Final Report - Corrections Required **Application No. LUPL-25-0008**

Report Date: 12/12/2025

Document Filename : 241010_BLR Village C Land Use Plan.pdf

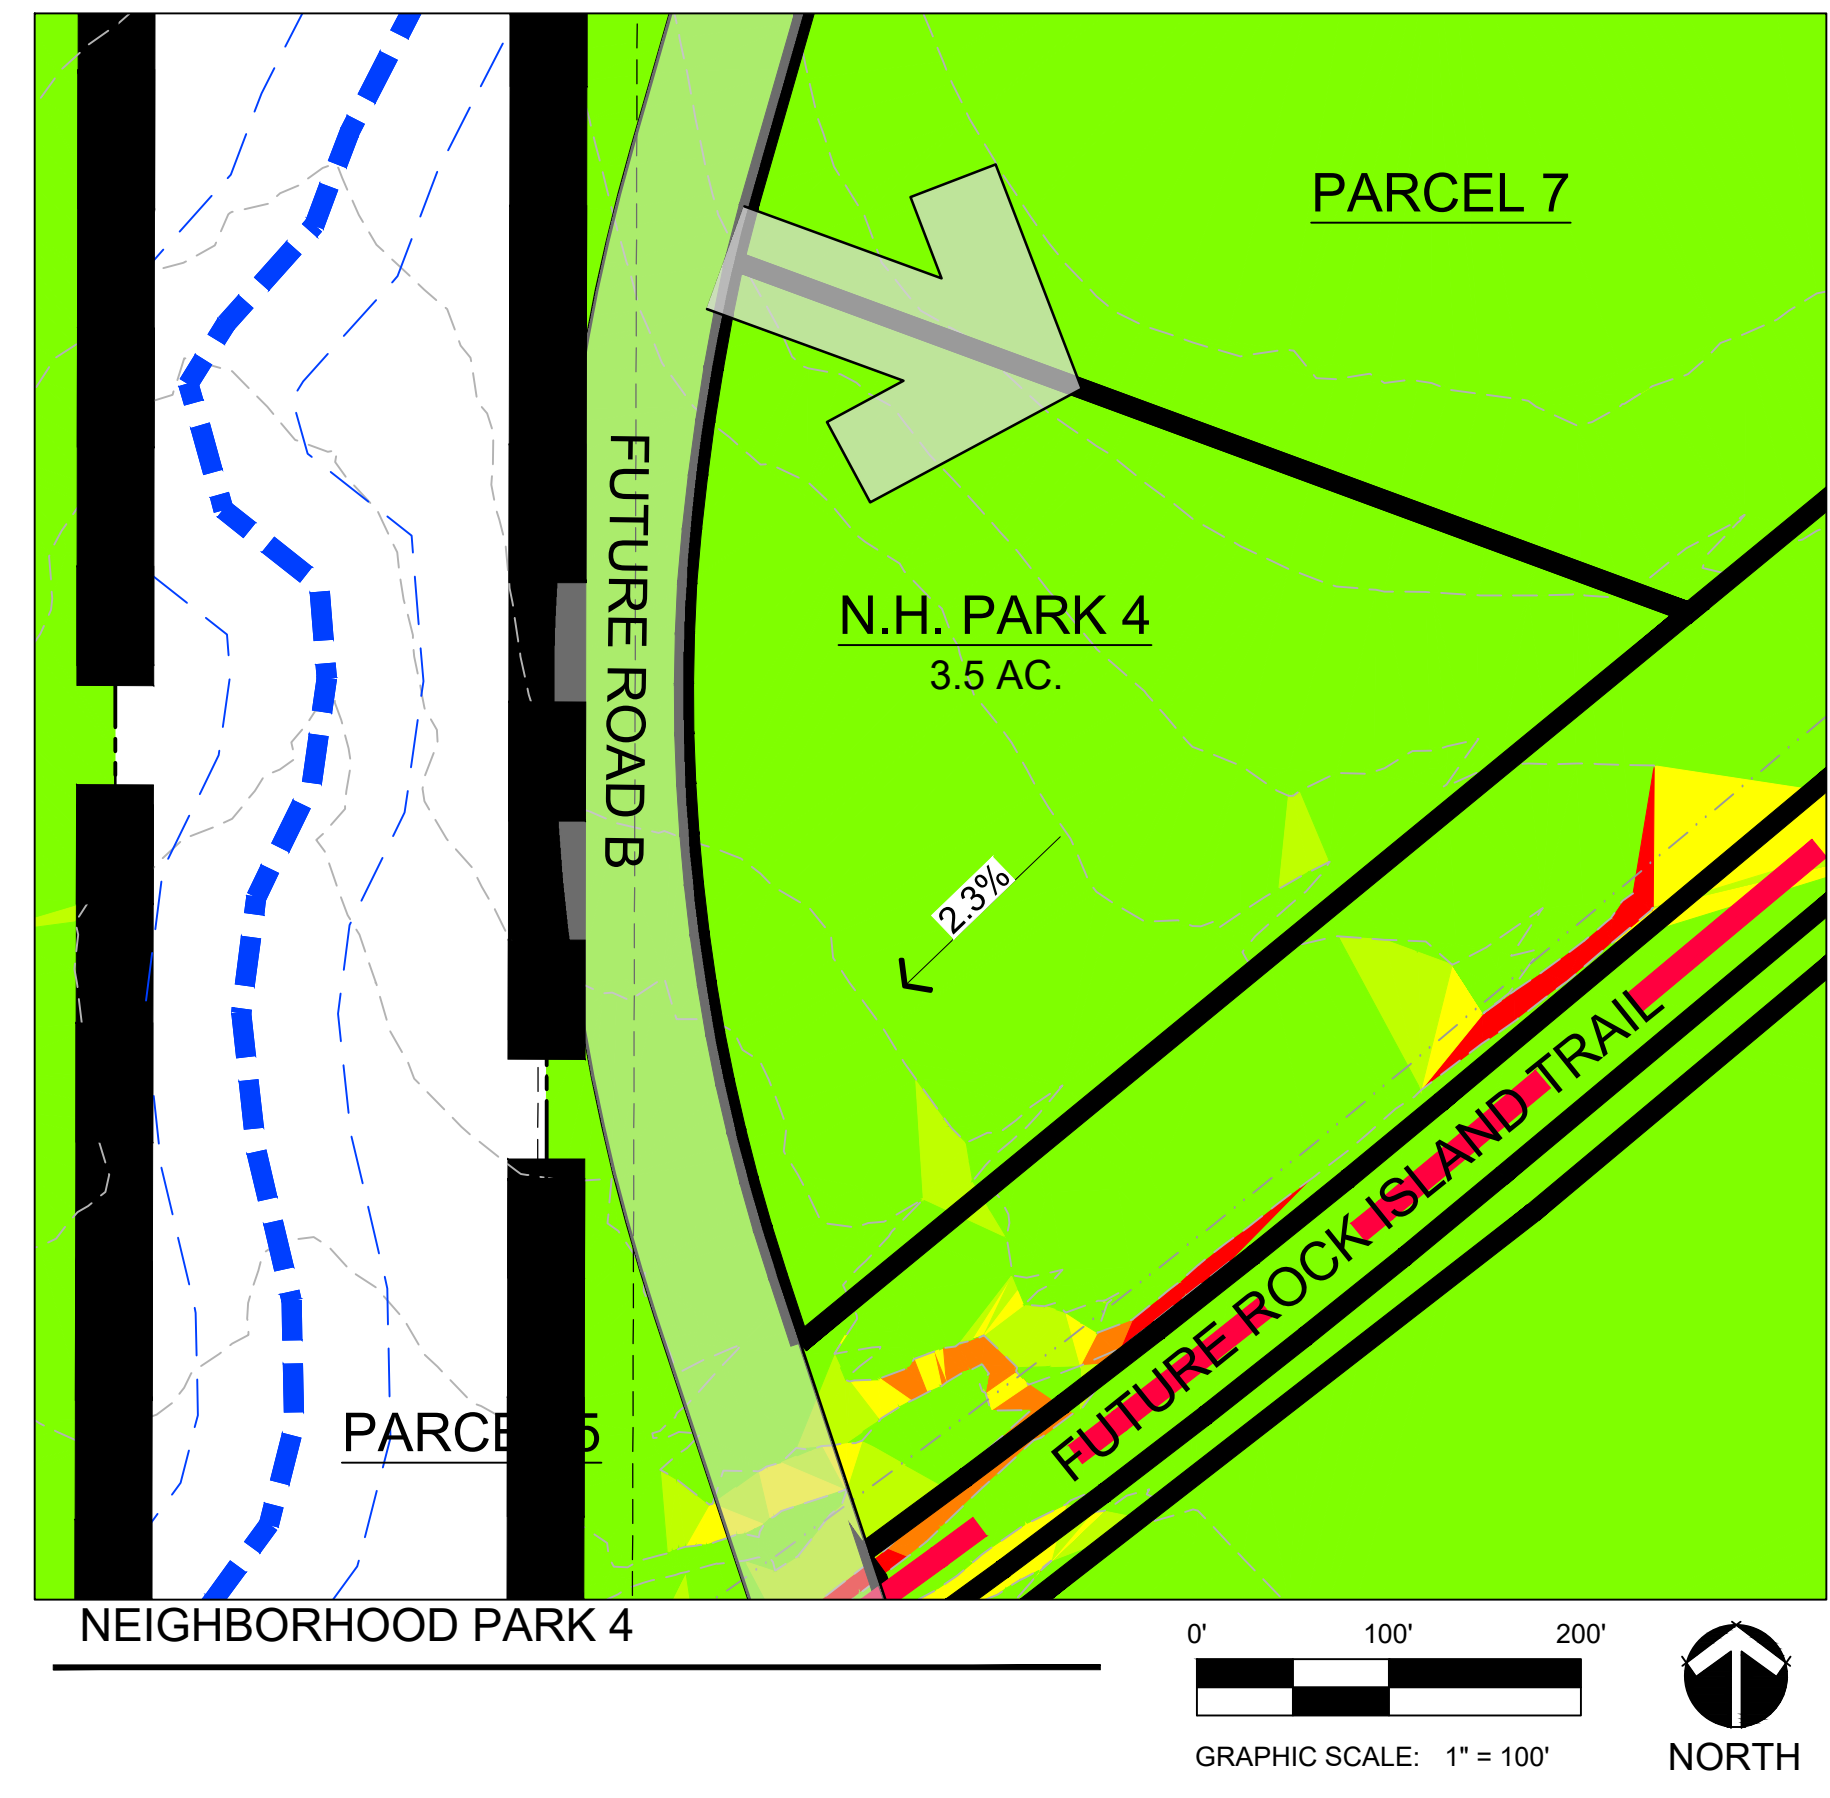
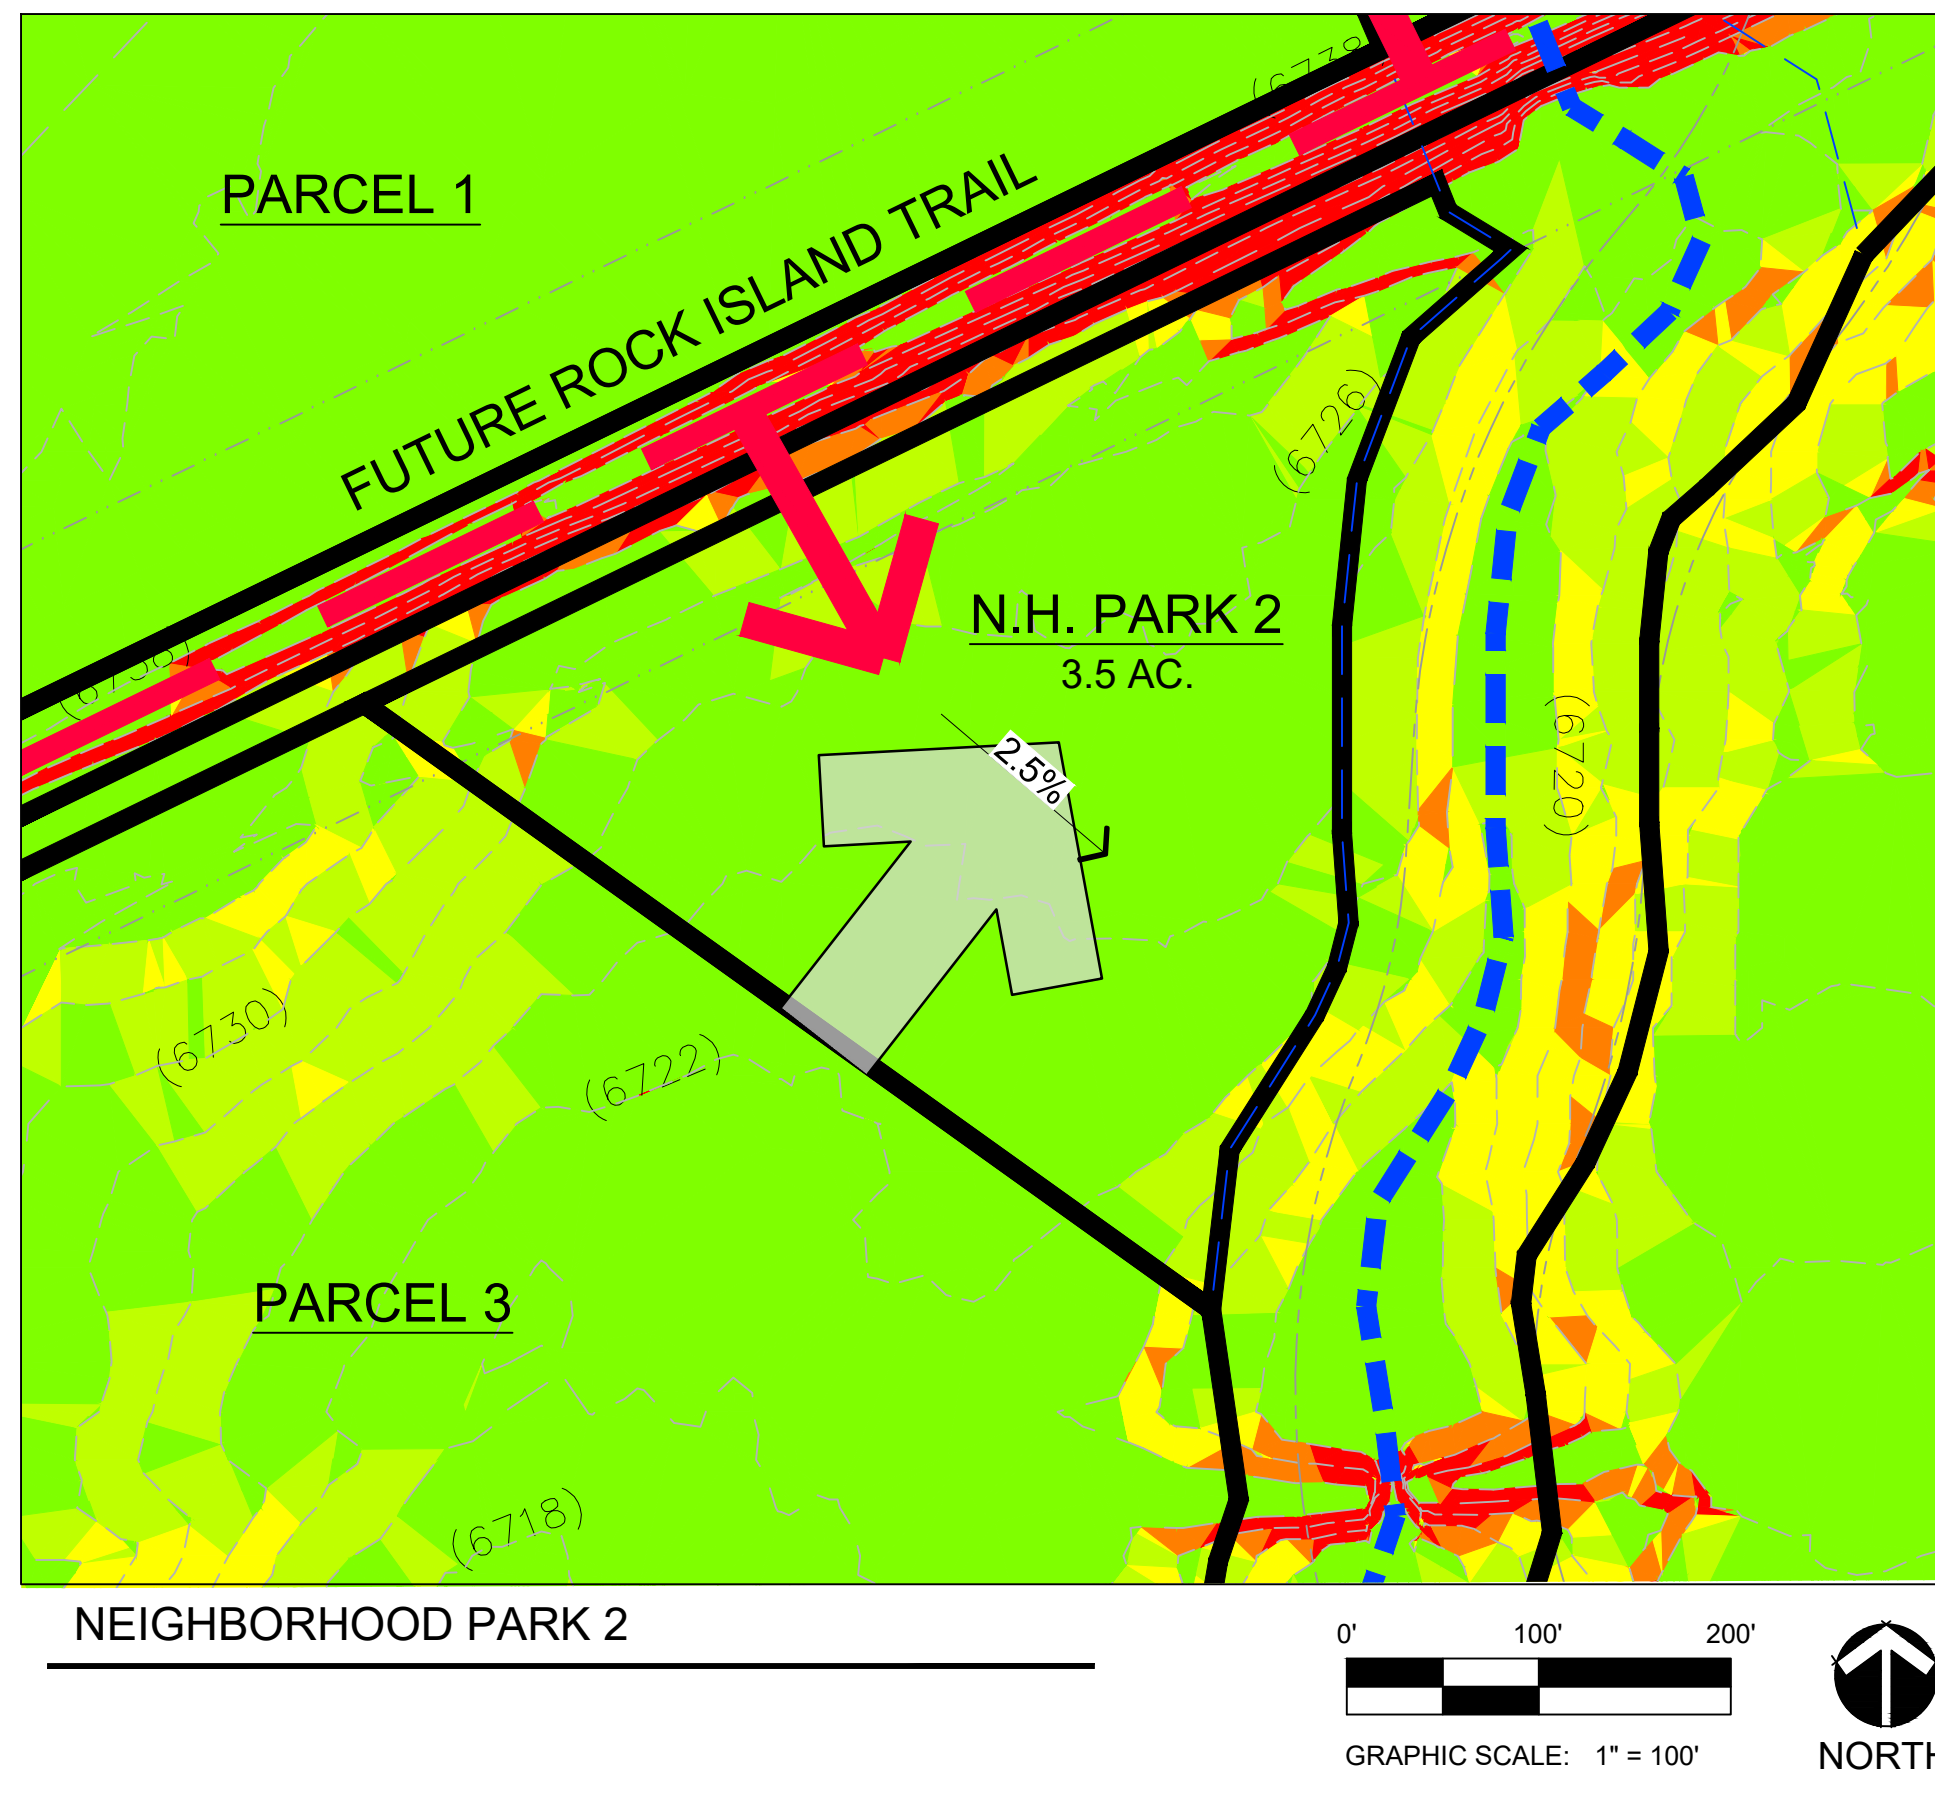
Comment ID	Page Reference	Reviewer : Department	Review Comments
15	1	Caroline Miller : Planning	<p>PLDO Reviewer would like for Village B2 and C to go to Parks Advisory Board prior to City Planning Commission to highlight PLDO obligations through the Master Plan/Land Use Plan and how they are to be met through the spread of Neighborhood Parks and summed Village C Community Park site. This will take two months, the first month as a presentation item, the second month as an action item, once Parks comments are resolved on Village C.</p> <p>In addition, Parks is awaiting feedback regarding the developer building the Community Park, then dedicating it to the city. A Community Park amenity list was provided in April to help the conceptual feasibility discussions. Notes will likely be added to this LUP in the future, upon developer response.</p>
25	2	District #49 : School Districts	PK-8 proposed
